**KIRKLEES METROPOLITAN COUNCIL
INVESTMENT & REGENERATION SERVICE**

**DELEGATED DECISION TO DETERMINE APPLICATIONS FOR
CONSENT, AGREEMENT OR APPROVAL REQUIRED BY CONDITION**

Reference No:	2024/44/90341/W
Site Address:	Land adj, 21, Thomas Street, Lindley, Huddersfield, HD3 3JJ
Description:	Discharge of conditions 4 (CMP), 5 (CEMP), 6 (surface water drainage), 11 (foul / surface drainage), 20 (BEMP) and 22 (invasive species) of previous permission 2023/91408 for erection of care home (Class C2) with sub-station, associated car parking, access, servicing, landscaping and other associated works
Recommending Officer:	William Simcock

DECISION – Discharge of Conditions – Split Decision

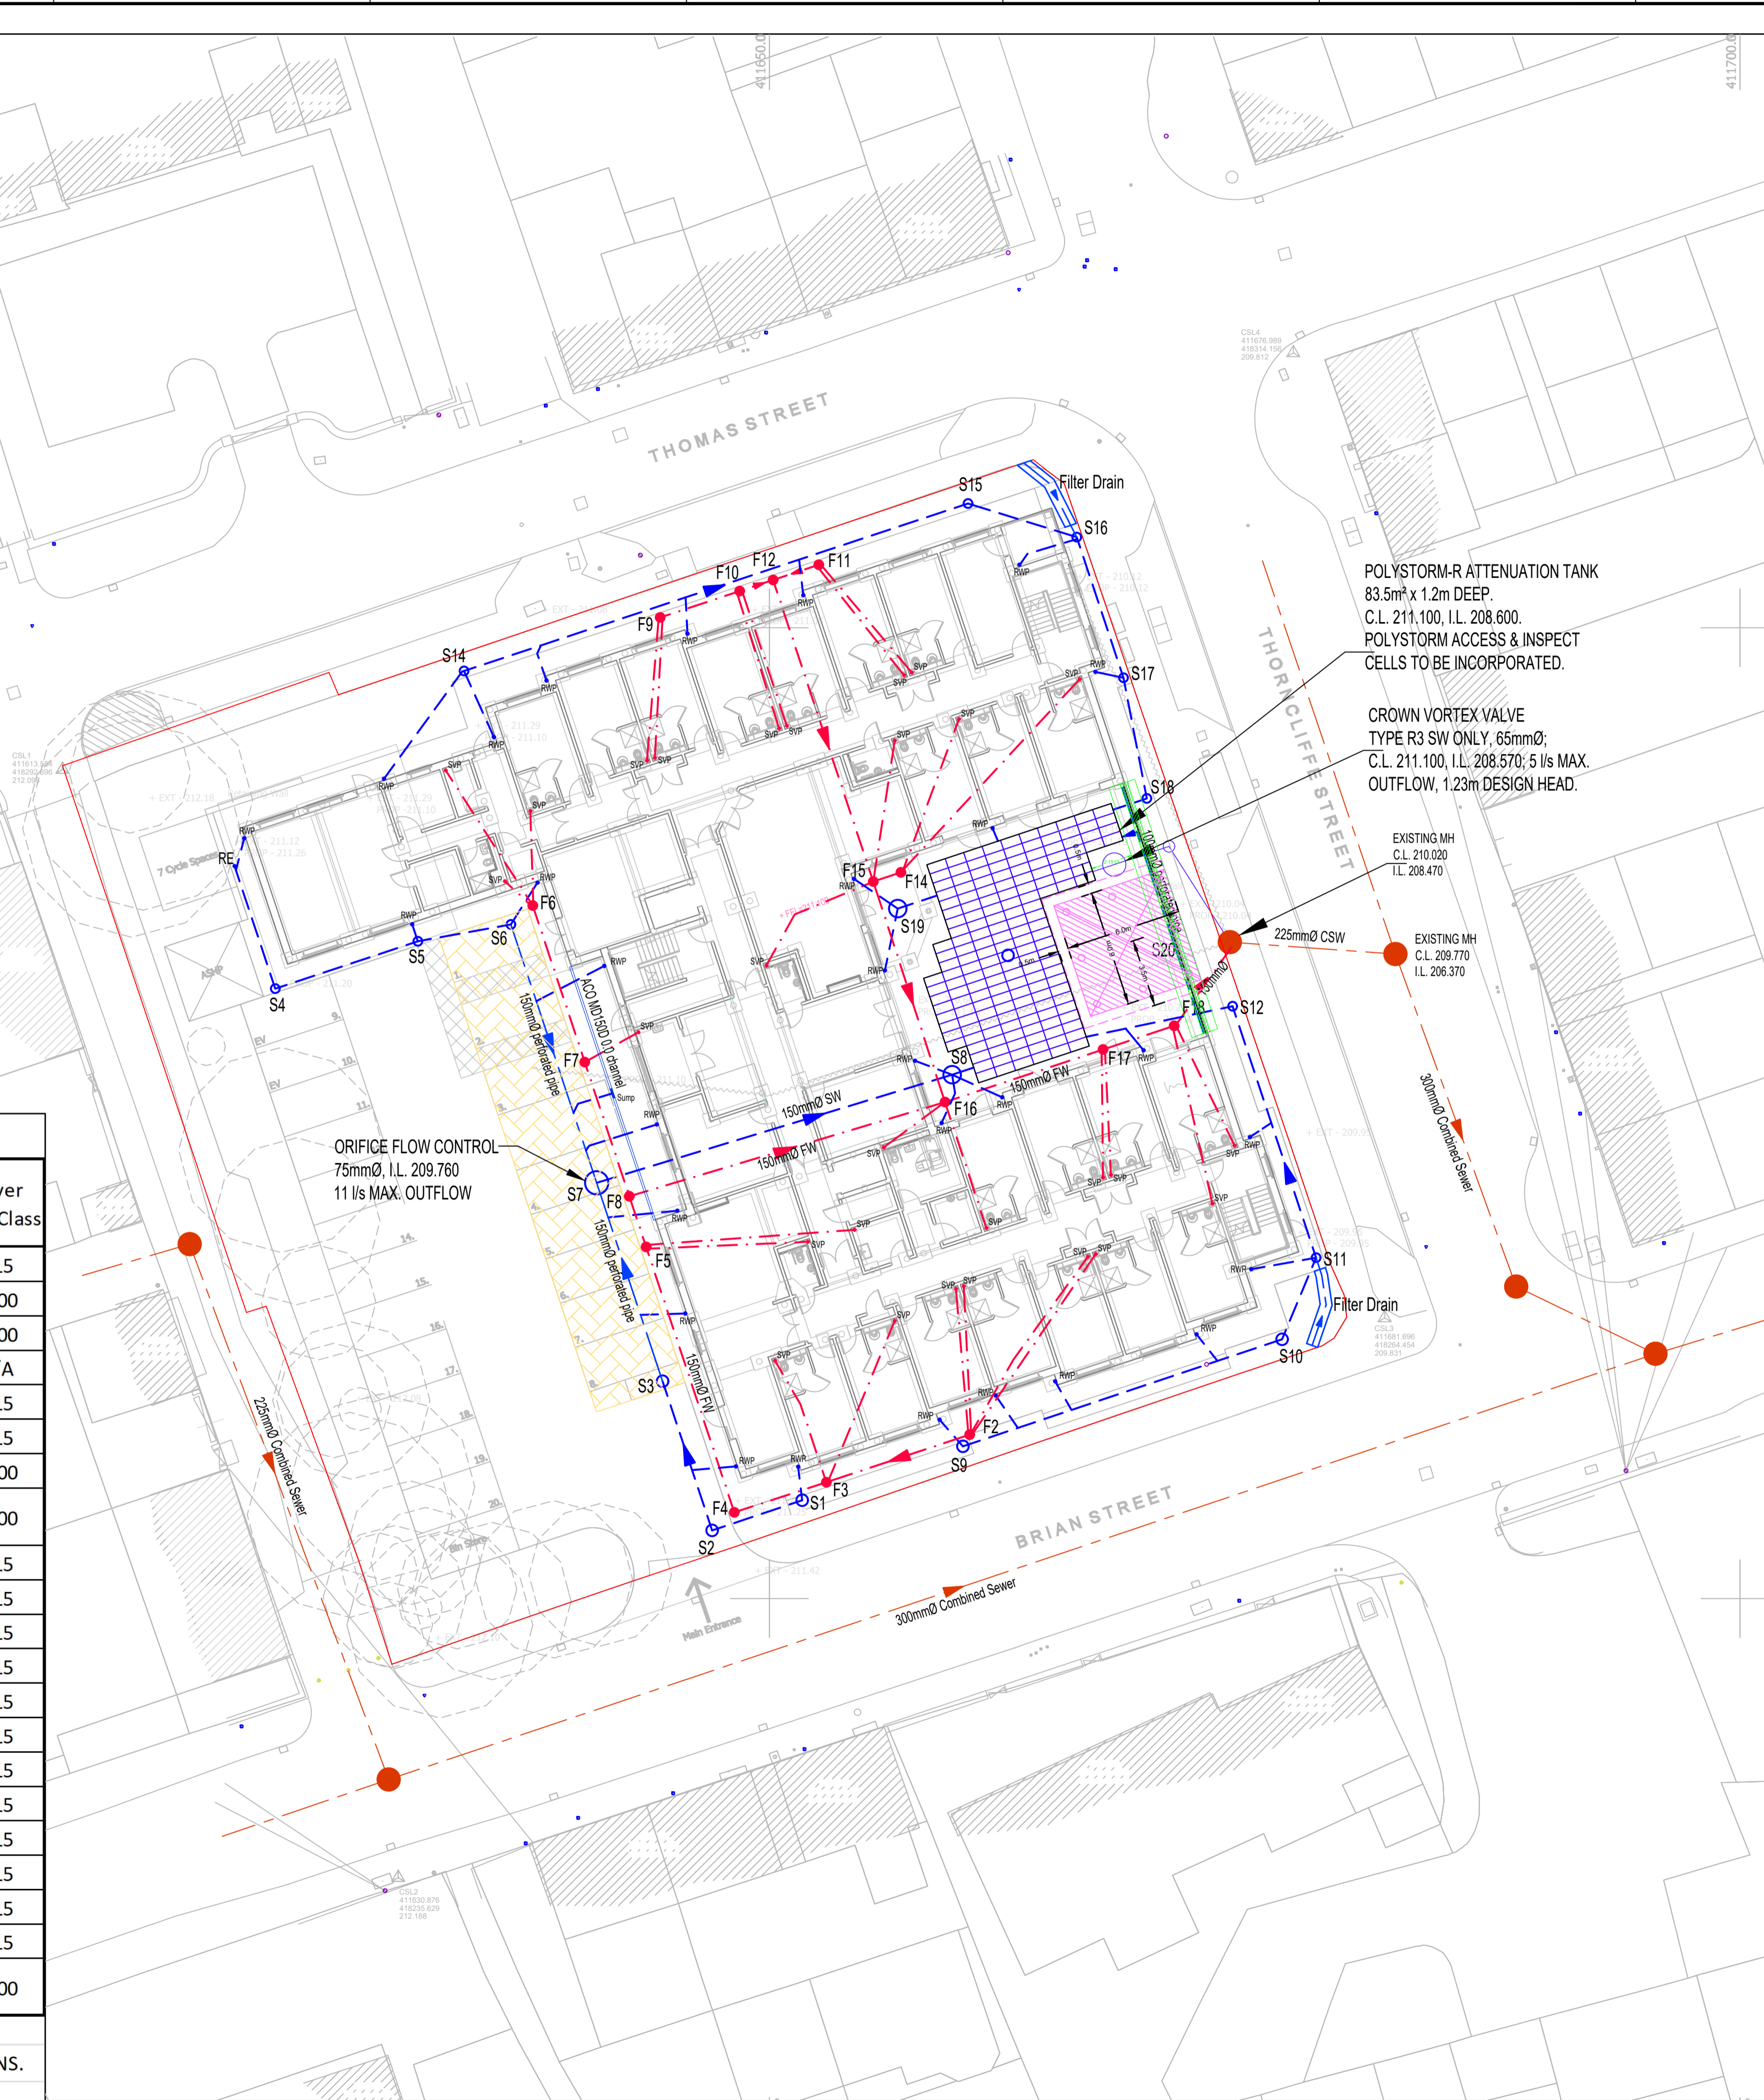
A Proposed Drainage Layout, reference 500 Revision D, has been submitted. The comments of the LLFA are as follows:

- Drawing is stamped “Work In Progress” – but it is not clear what further changes or updates are proposed.
- The drawing shows a Polystorm R Attenuation Tank but calculations confirming its size have not been provided.
- Surface water manholes S12 and S18 upstream of attenuation tank will need to be catchpits as these are connected to filter drains.

Further information and amendments are required as noted above and therefore an approval pursuant to condition 11 cannot be issued at this time.

ITEM 2: TEMPORARY ATTENUATION TANK TO STORE WATER FROM LAND DRAINS FOR CONSTRUCTION PHASE. INSTALLED AT A LEVEL BELOW FORMATION LEVEL

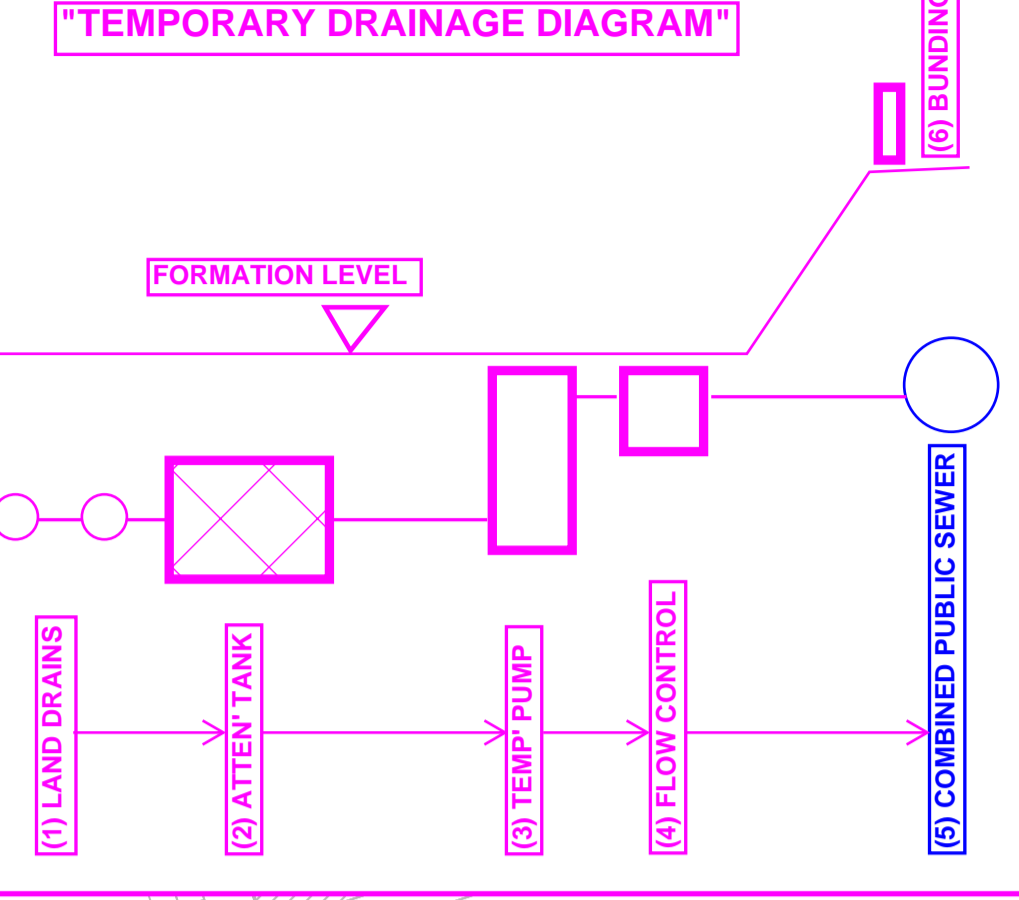
A temporary drainage diagram, forming part of drawing 500 Revision D, has been submitted. The comments of the Lead Local Flood Authority (LLFA) are as follows:

- The drain from the temporary storage tank (Item 2) is shown passing under the crane mat (also Item 2) and is not shown connecting to the temporary SW pump chamber (Item 4).
- It does not provide details of how the flow rate from pump chamber will be controlled to be no greater than 2.5 l/s per ha as stated in condition 6.
- Calculations should be provided confirming that the temporary storage tank is of sufficient capacity for the critical 1 in 2 year rainfall event with the outlet controlled to the above rate.

Further information is required as noted above and therefore an approval pursuant to condition 6 cannot be issued at this time.
